March 3, 2016

Re: Site Plan II Application - Additional Site Revisions  
 Proposed Taco Bell, 1363 Washington Ave, Portland, ME

Site Access Management Figure  
 Proposed Taco Bell  
 1363 Washington Avenue  
 Portland, Maine

Not Approved for Construction  
Drawing Title  
**Layout & Materials**

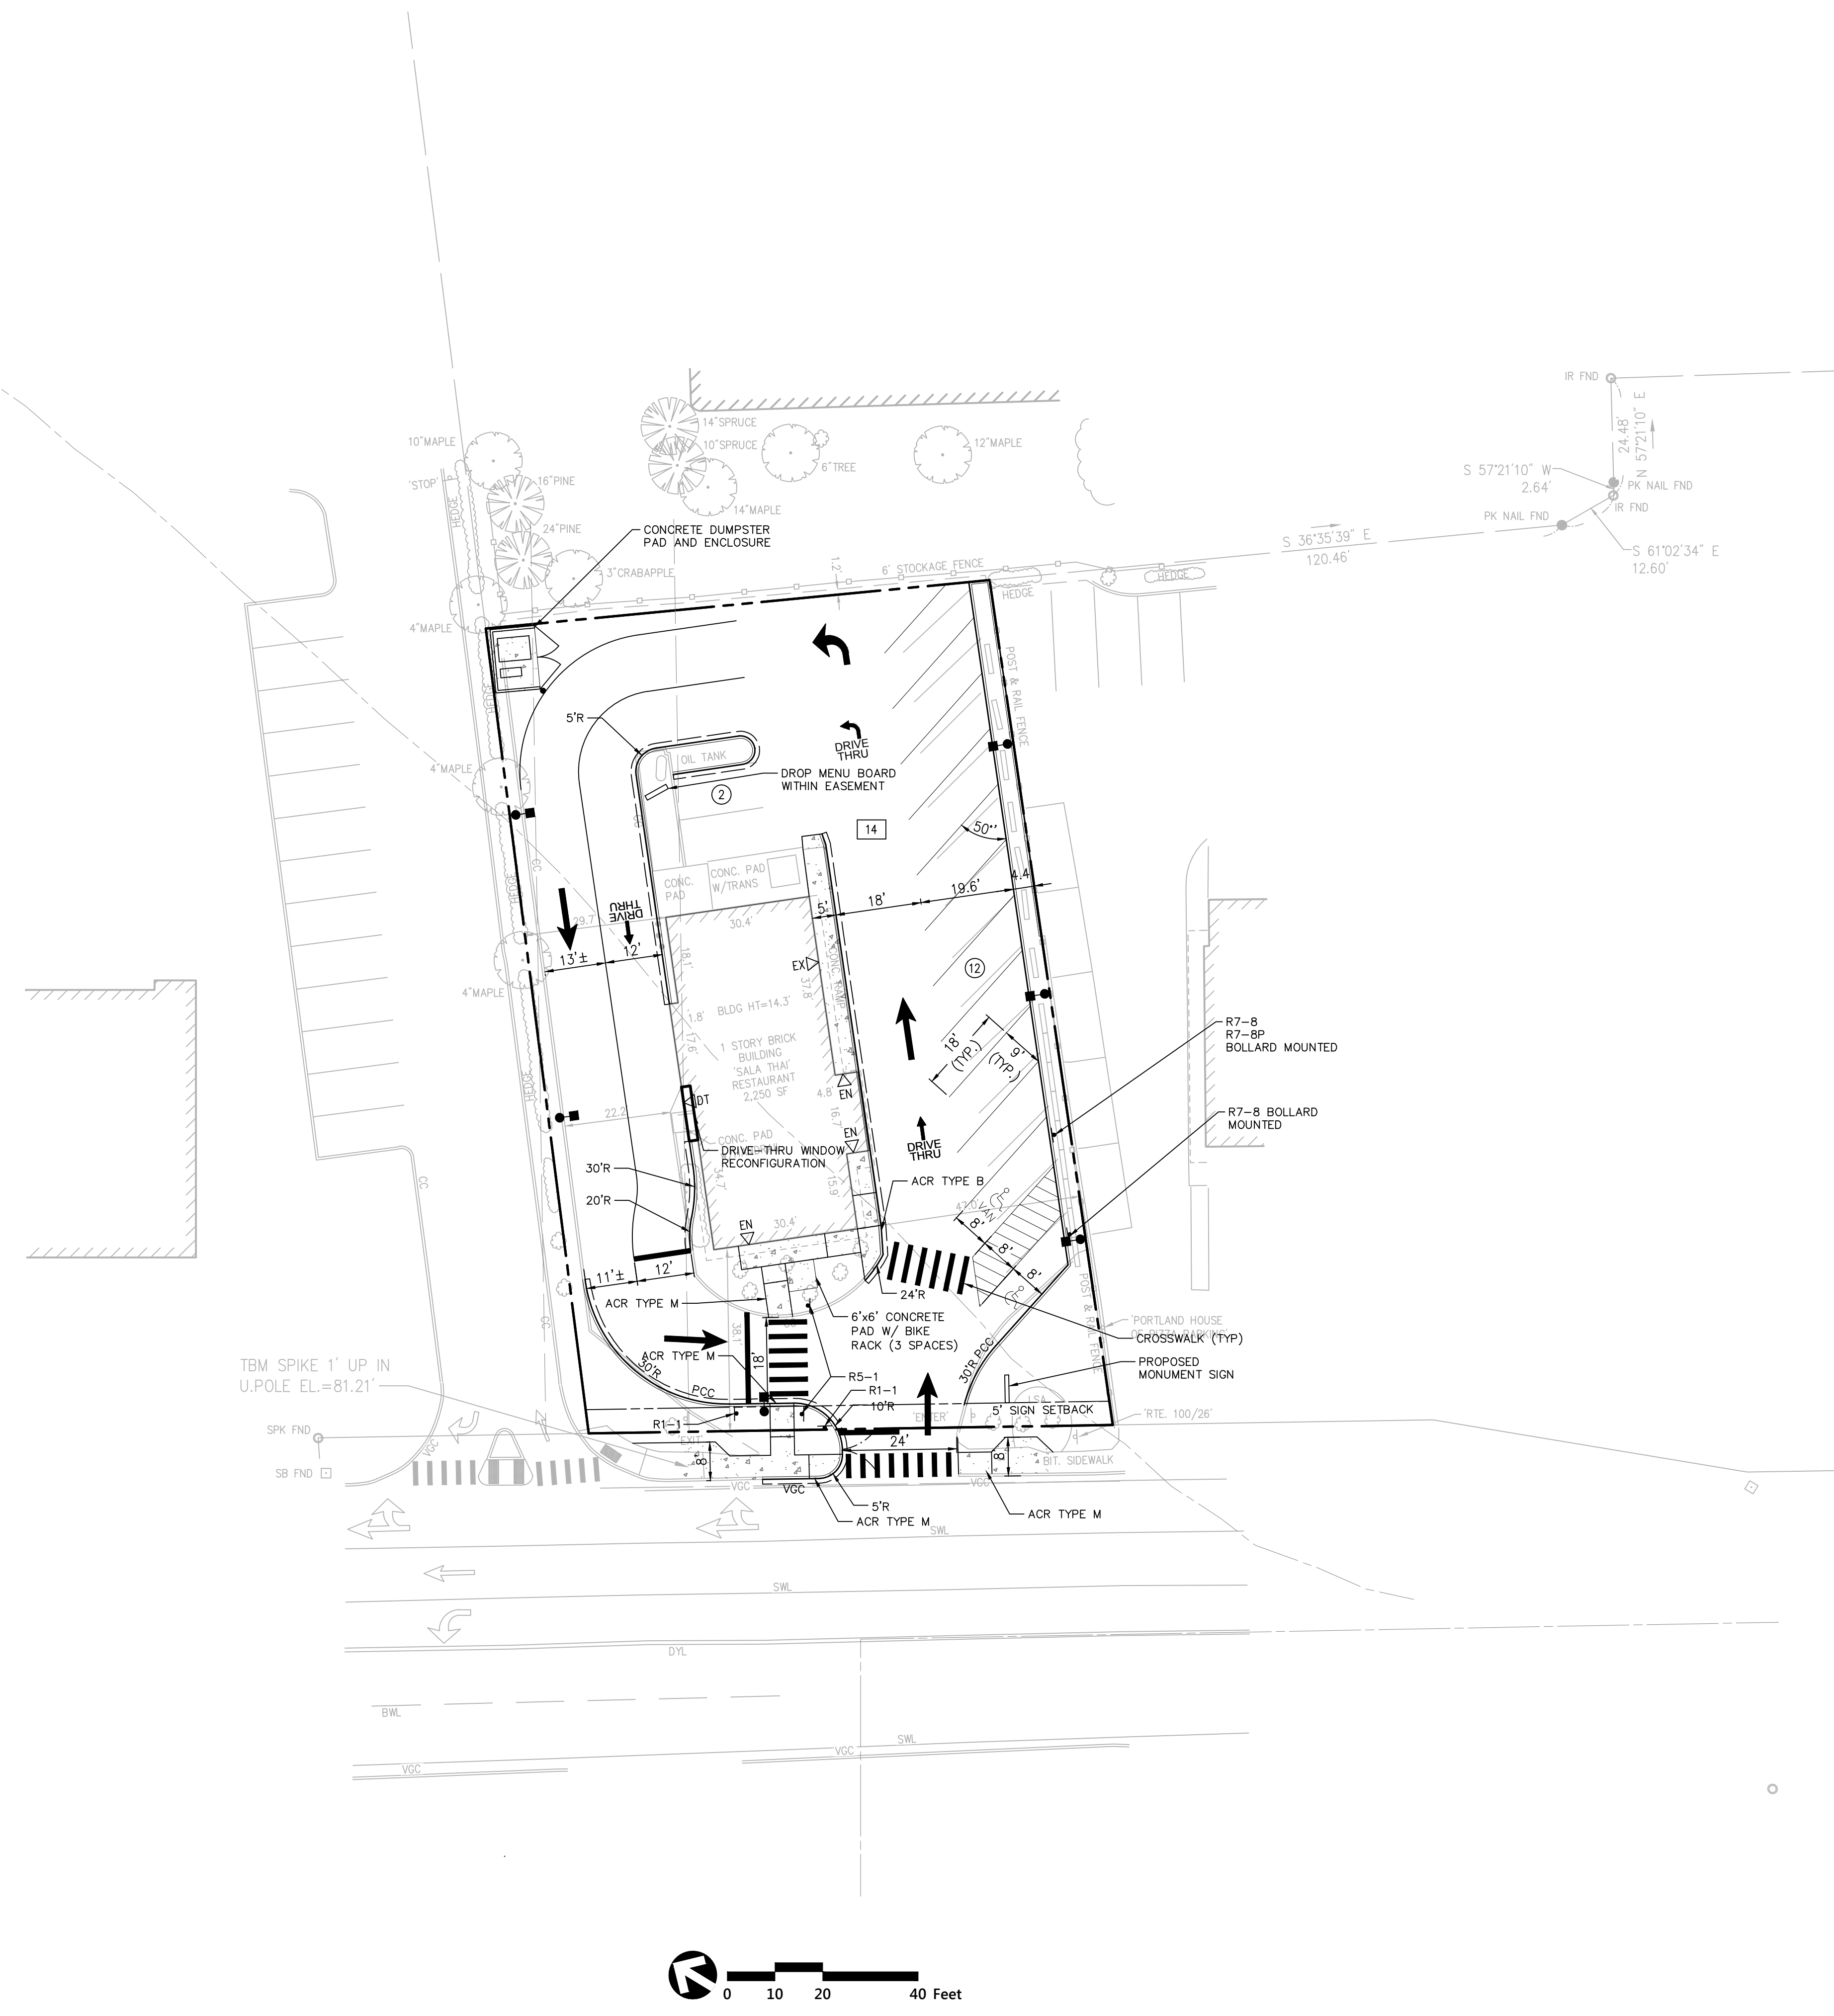
1. The sidewalk along Washington Avenue has been modified to be 8-feet wide along the entirety of the property width, see attached figure.
2. To further clarify the response to the Planning Departments comment on zoning, a 4-foot wide landscape island was added along the southeast property line. The parking has been revised to accommodate this by restriping the existing non-standard spaces. As noted in the in the Technical Standards Manual (Figure I-28), there are two options for the angled parking defined (45 degree and 60 degree). VHB has proposed the use of 50-degree angled parking to maintain the same number of spaces in the existing row of parking while creating a 4-foot wide, plant-able, landscape island between the site and the Portland House of Pizza, as the two standards sizes in the manual resulted in layout impacts. As shown in the table below, the proposed layout is reasonable compared to the standard sizes.

3. Based on additional discussions, VHB has looked at potential improvements for access management in the area of the drive thru window exit. VHB is proposing a stop bar approximately 24' from the drive thru window and a speed bump immediately after, across the drive thru lane and the by-pass lane. This will provide traffic calming measures for the drive-thru users and the customers using the by-pass lane prior to the pinch point when turning left in front of the building, see attached figure.
